RE: Del Sol Condos
8300 Comanche Rd. NE
Grading & Drainage Plan
Engineer's Stamp Date: 03/31/2025
Hydrology File: G19D003A
ABQ-PLAN No.: SI-2025-00085

Based upon the information provided in your submittal received 03/31/2025, the Grading & Drainage Plan is **not** approved for a Grading Permit or Building Permit. The following comments need to be addressed for approval of the above referenced project:

DEL SOL CONDOS
DRAINAGE ISSUES
CONSTRUCTION DOCUMENTS
DETAILED GRADING PLAN - SOUTH

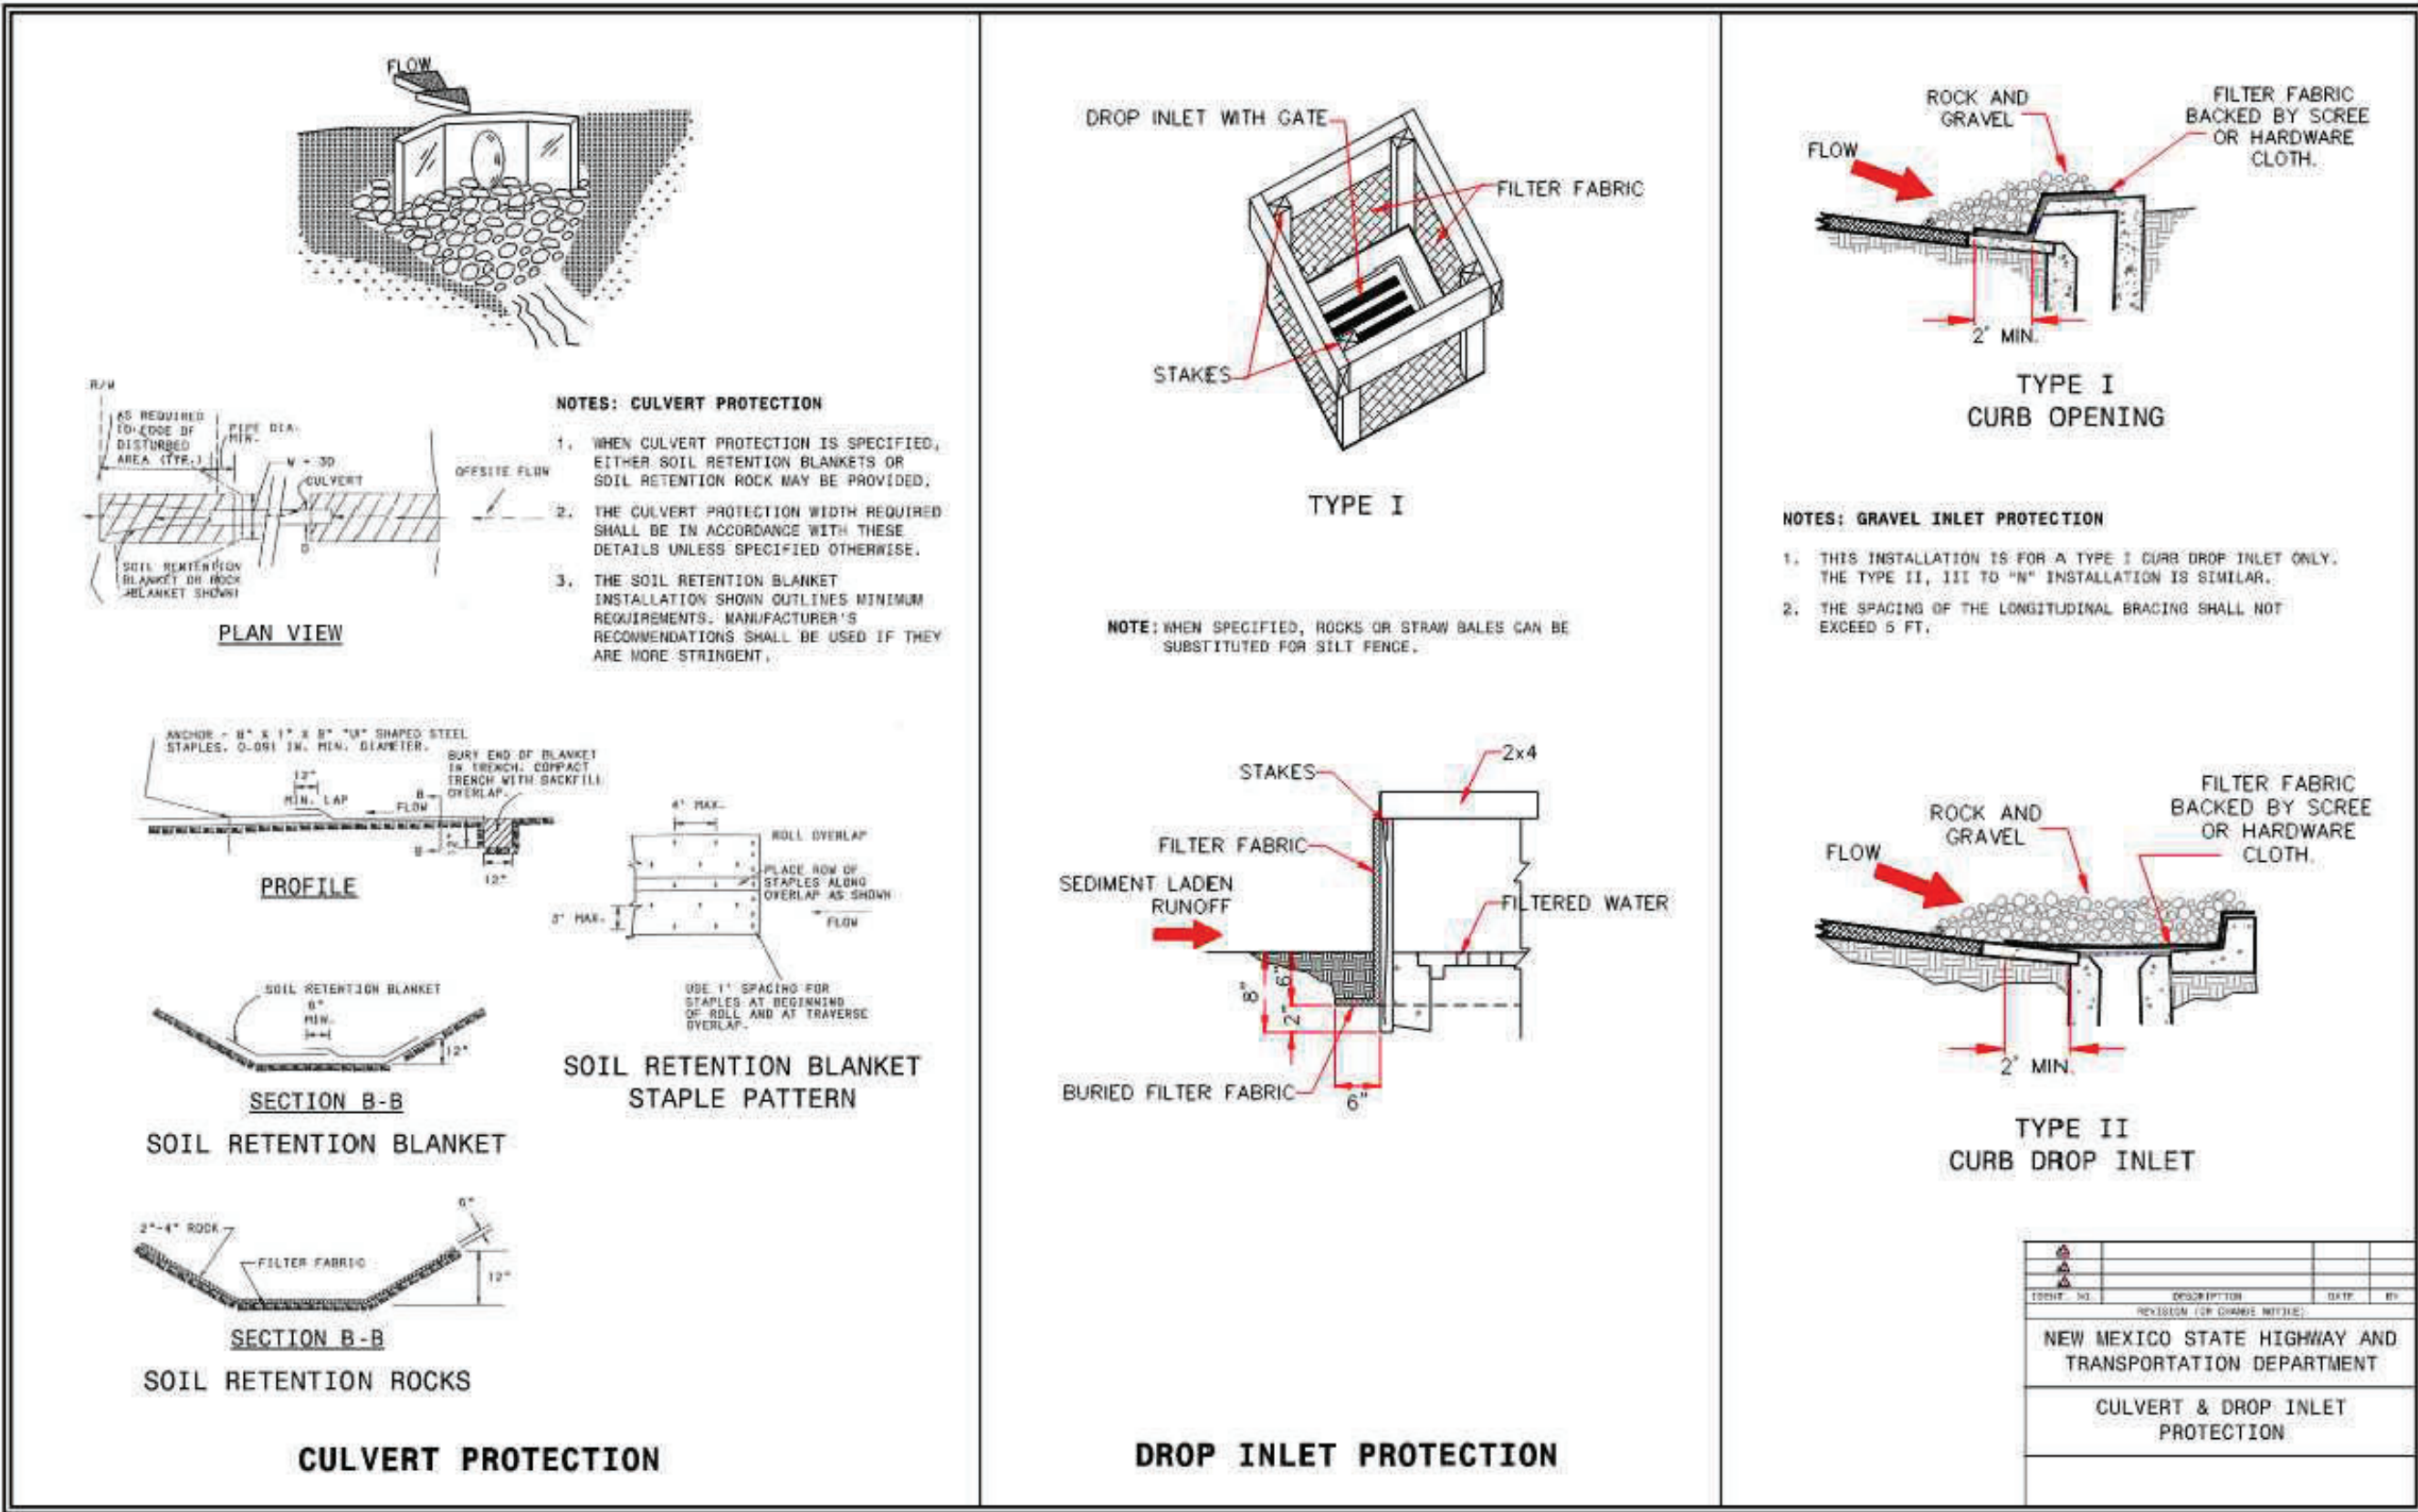
5. The attachment in the ABQ-PLAN file for this project is an Application for Payment in Lieu Form for your review and processing, if you choose this direction.
6. Please review the proposed drainage swale at the southerly property boundary and include in the SWQV and include in items No. 2 and No. 3, above.
7. Prepare and provide a response to each of the above items in a subsequent re-submittal for further review.

DEL SOL CONDOS
DRAINAGE ISSUES
CONSTRUCTION DOCUMENTS
PROPOSED DRAINAGE PLAN

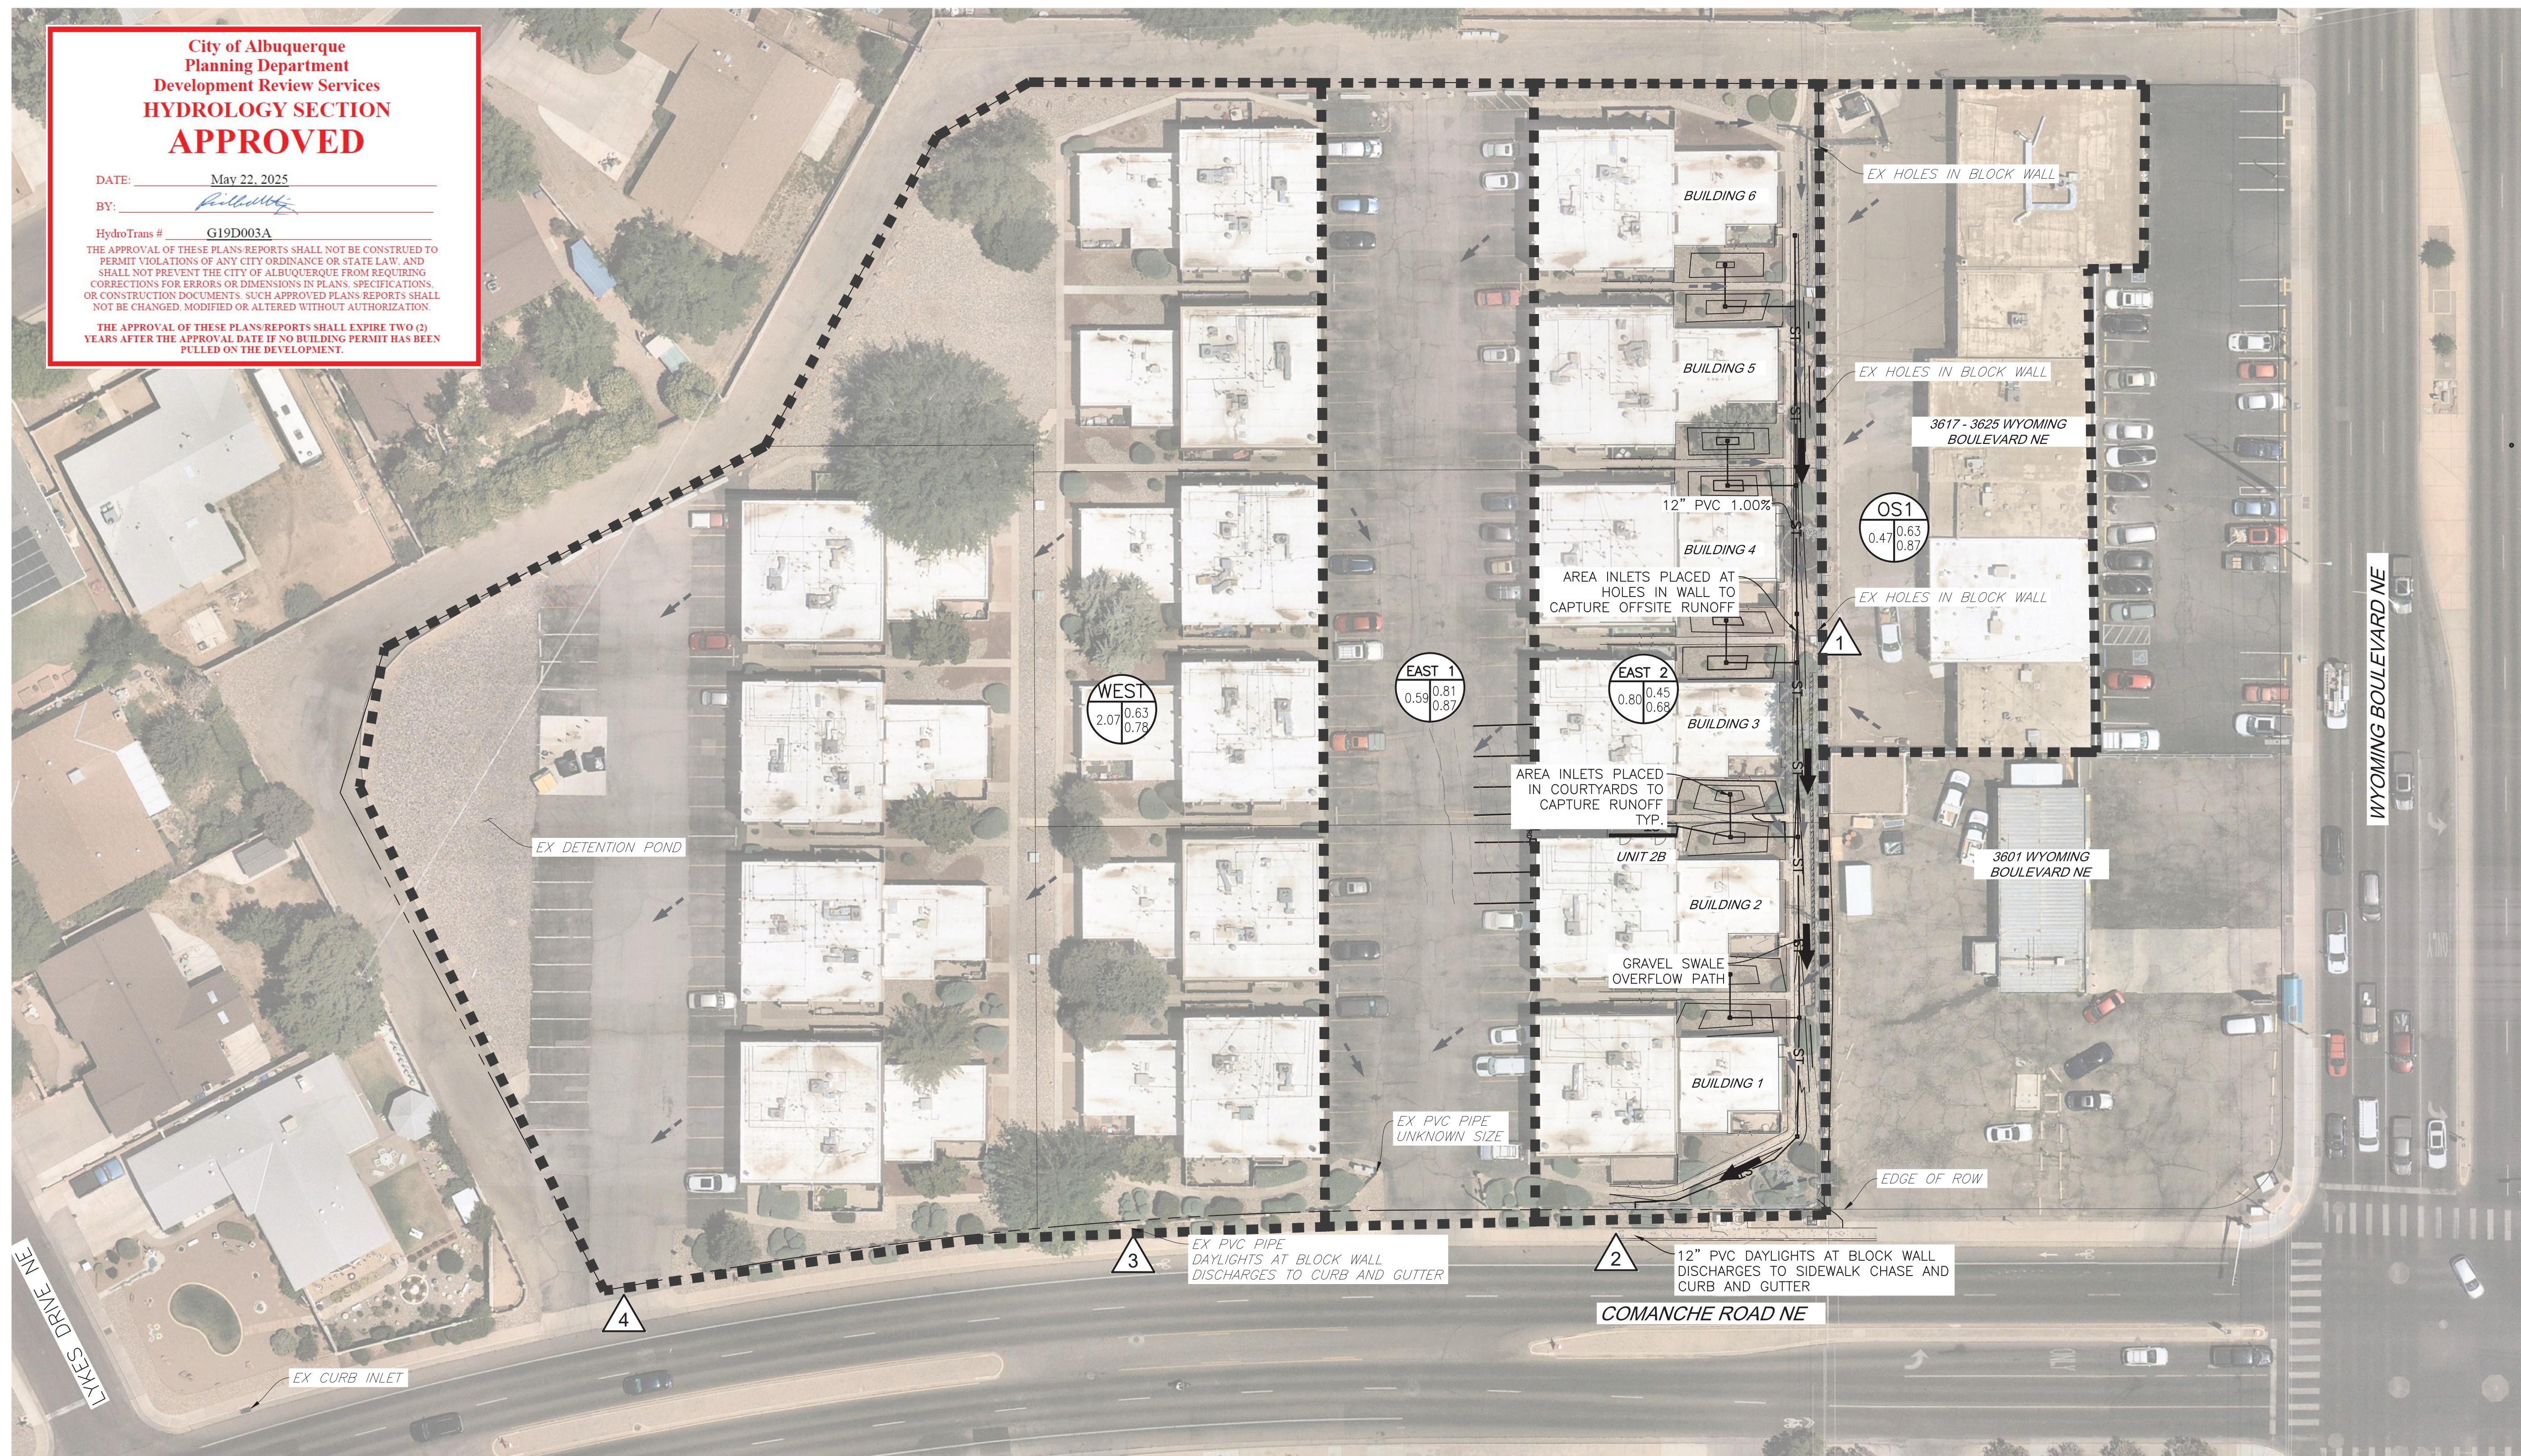
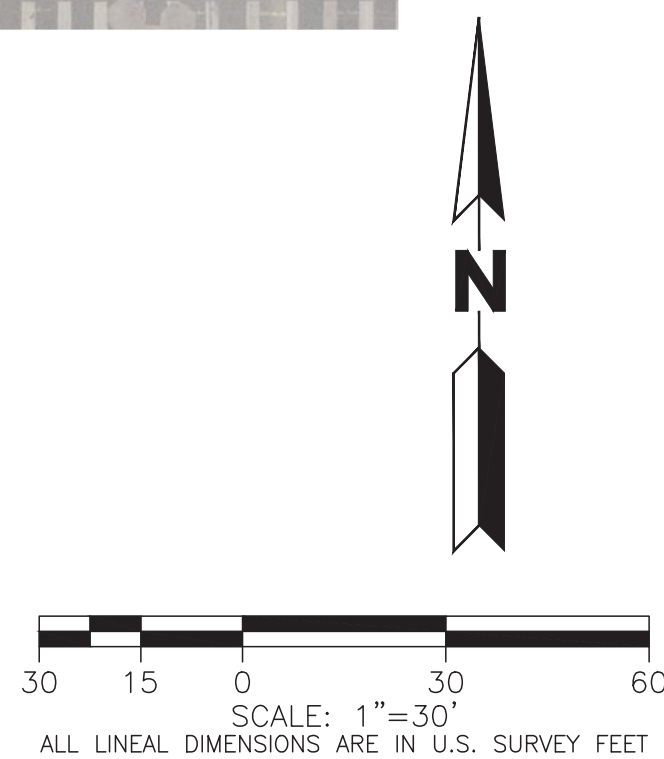
1. Provide management onsite for the Stormwater Quality Volume (SWQV) in accordance with the new drainage ordinance, § 14-5-2-6 (H). Please show the top and bottom of the ponds along with the volume for each pond. The onsite drainage should be directed to these ponds prior to being collected in a private unground drainage system. Please follow the DPM Article 6-12 Stormwater Quality and Low-Impact Development for the sizing calculations. To calculate the required SWQV, multiply the impervious area draining to the BMP by 0.42 inches for new development sites and 0.26 inches for redevelopment sites. The calculations of both the required and the provided volume of each BMP must be shown on the Grading and Drainage Plan. Each BMP should be labeled on the Grading and Drainage Plan with the required SWQV and associated water surface elevation and the 100-year water surface elevation. Landscaping of surface BMPs is also required to be noted on the Grading and Drainage Plan.

2. Stormwater from the independent collection ponds or depressed landscape stormwater collection ponds should be included in the overall SWQV determined for discharge at the southern property boundary / Comanche Rd. ROW.

3. For this SWQV pond, please the SWQV and elevation, the 100-year volume and elevation, the peak 100 year inflow and outflow, the drainage elevation, and the ponding depth.
